REPORT UPDATE

Application No: A/83/18/RES

Recommendation Report for Approval of Reserved Matters Following Outline Approval

LOCATION: Land west of Brook Lane
and south of A259
Rustington
BN16 3JL

drawing number SPRUST(BROOK LANE).1/10 rev. D

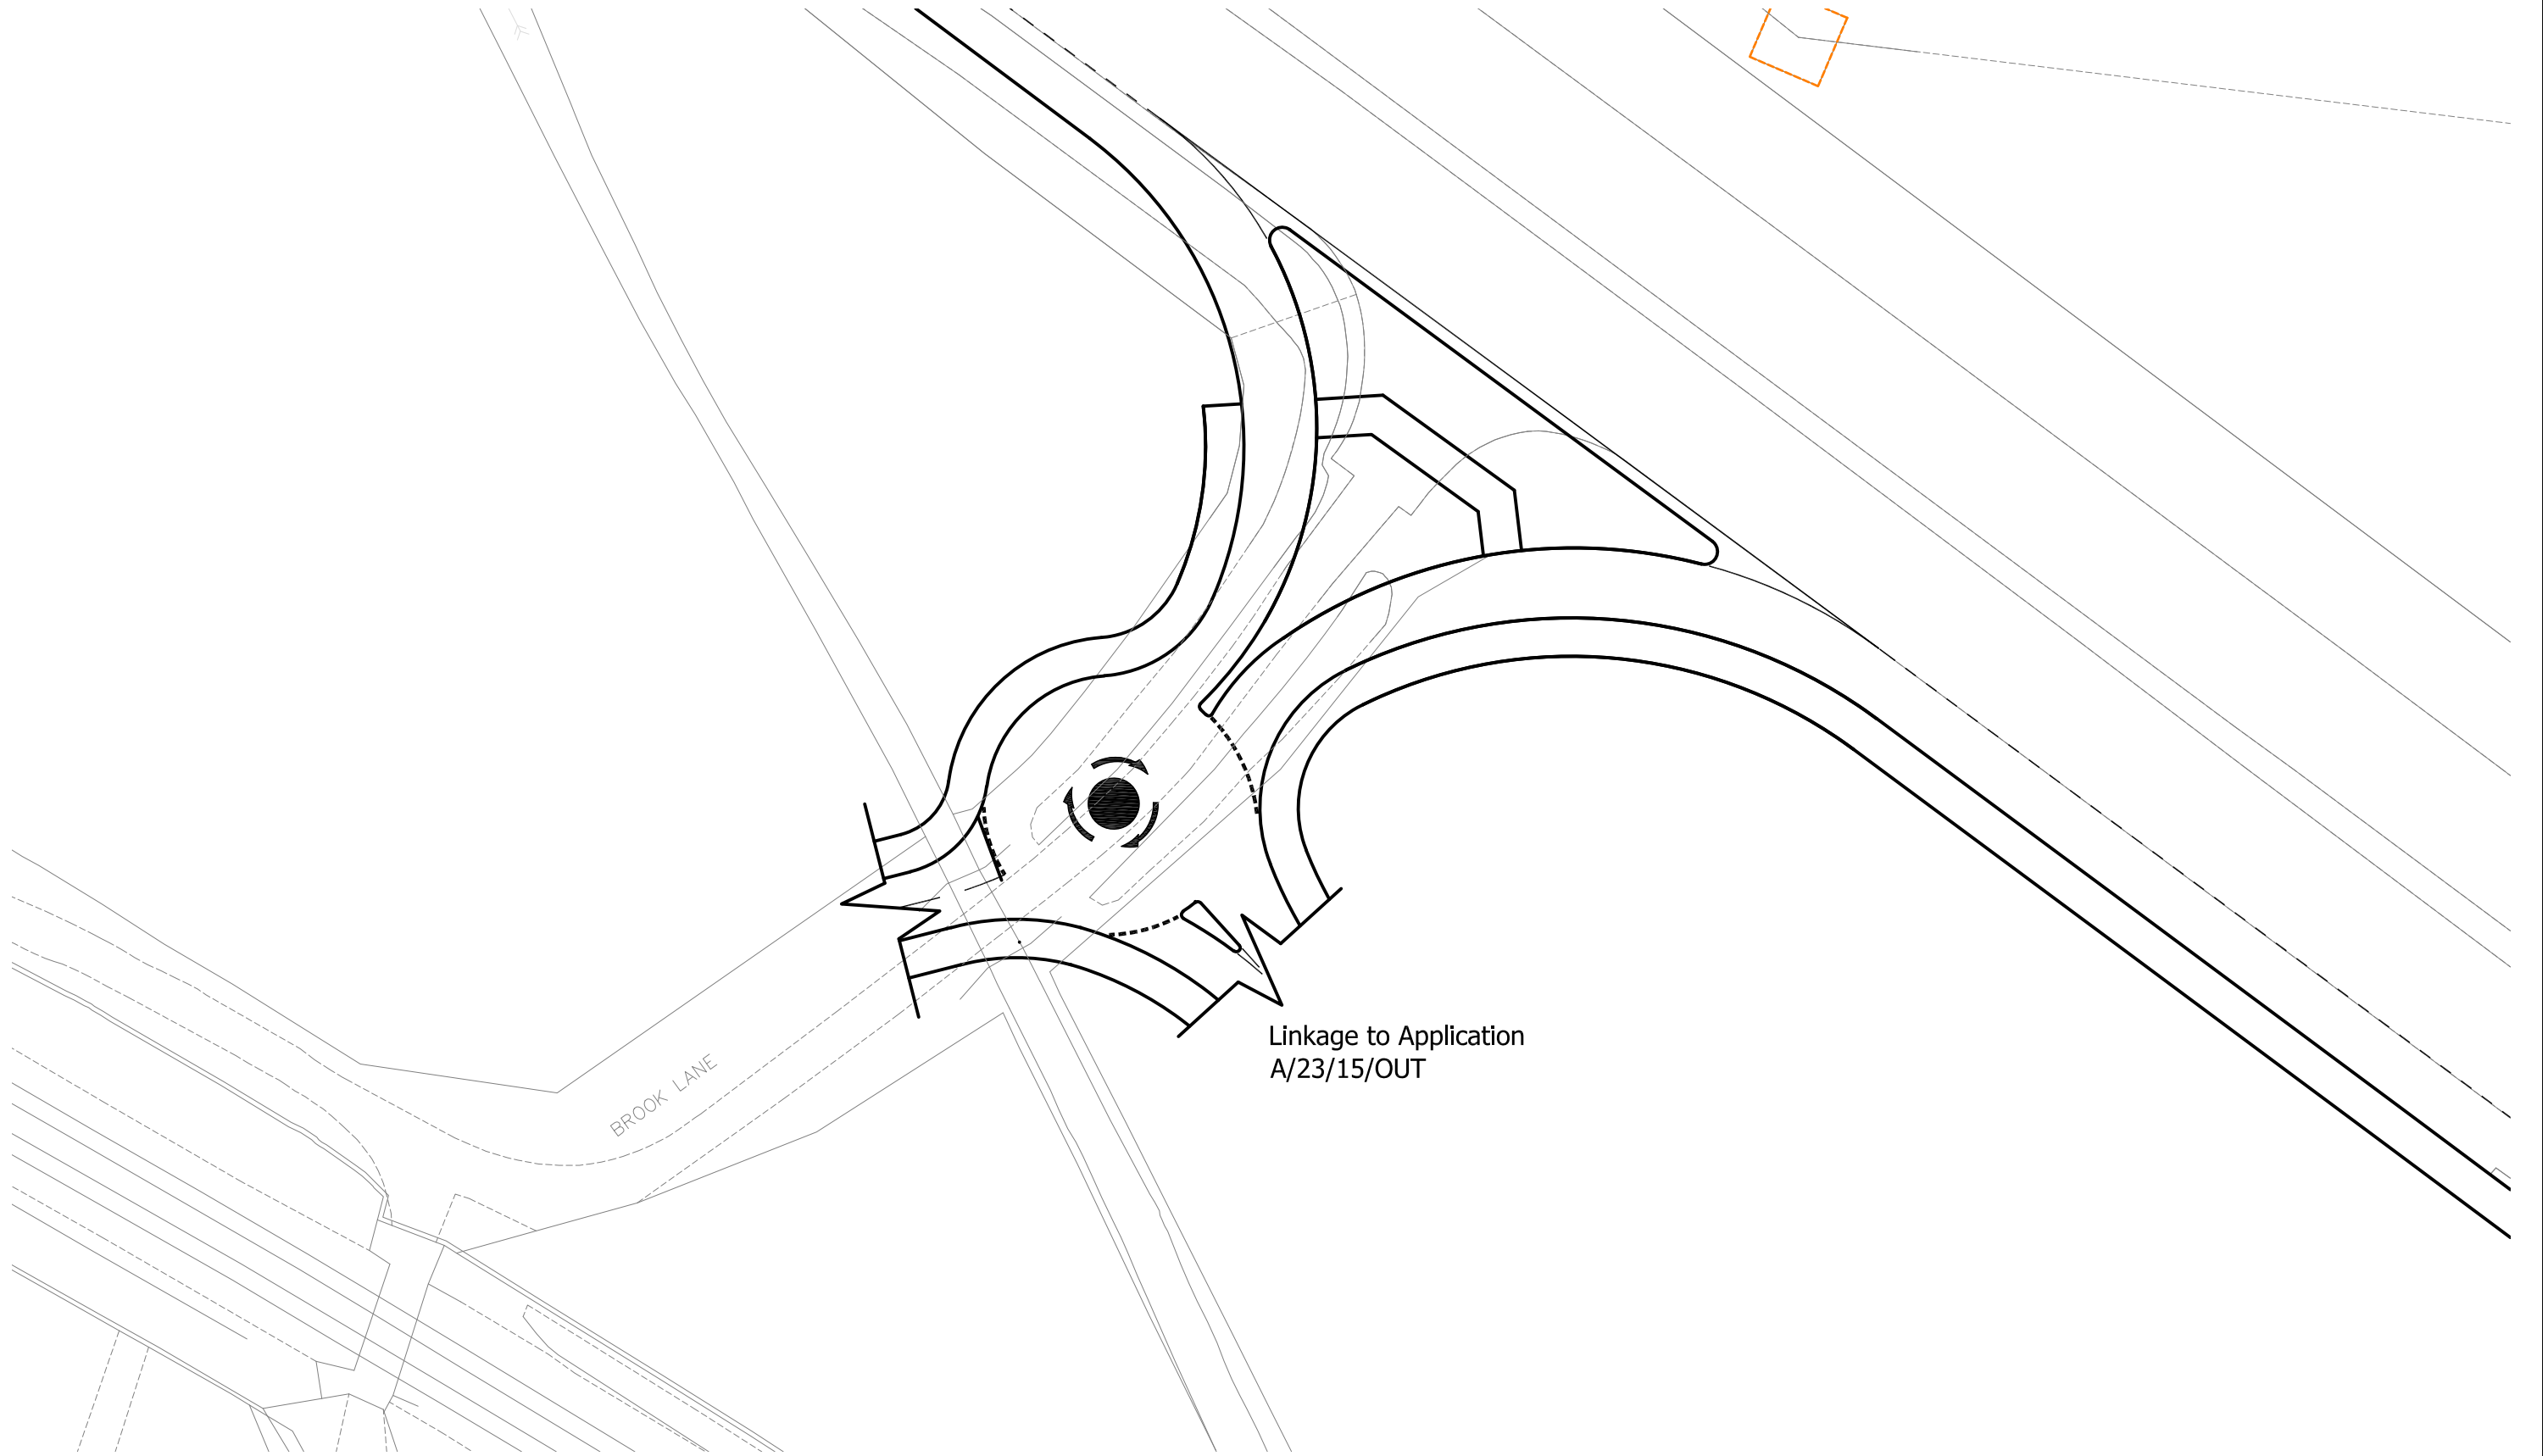
Observations made in relation the width of the merge and diverge traffic lanes

Dimensions of the acceleration/ deceleration lanes acceptable

Comment on the 30m radius being less than the 40m states as being preferable which is not addressed in the design review.

Demonstrates that proposed access does not preclude A/23/15/OUT from coming forward, subject to rights of access which are a private non planning matter.

Conditions recommended relating to access to be provided prior to occupation and that further details of the island providing a means of crossing for pedestrians on the eastern arm of the mini-roundabout to be provided.

The condition recommended by the LHA in relation to the pedestrian crossing point on the eastern arm of the roundabout relates to land outside the applicants control. The proposed roundabout for A/23/15/OUT includes detail of a crossing point in this location.

Drawing no. SPRUST (BROOK LANE).1/10 Rev D' has demonstrated that the proposed vehicular access would serve the residential development and would provide access to the mixed-use retail scheme on the adjacent site (under reference A/23/15/OUT) through the incorporation of a roundabout.

It has been demonstrated that safe access can be achieved at the site and to the adjoining site through the provision of a roundabout as specified on drawing no. SPRUST (BROOK LANE).1/10 Rev D'. Therefore, the proposed access is deemed to accord with policy T SP1 of the Arun District Local Plan (2011-2031); TM1 of the Angmering Neighbourhood Plan; and will not result in a severe impact upon highway safety in accordance with Paragraph 109 of the NPPF.

- 1 The development hereby approved shall be carried out in accordance with the following approved plans: Proposed Site Access - SPRUST (BROOK LANE) 1/10 REV D.
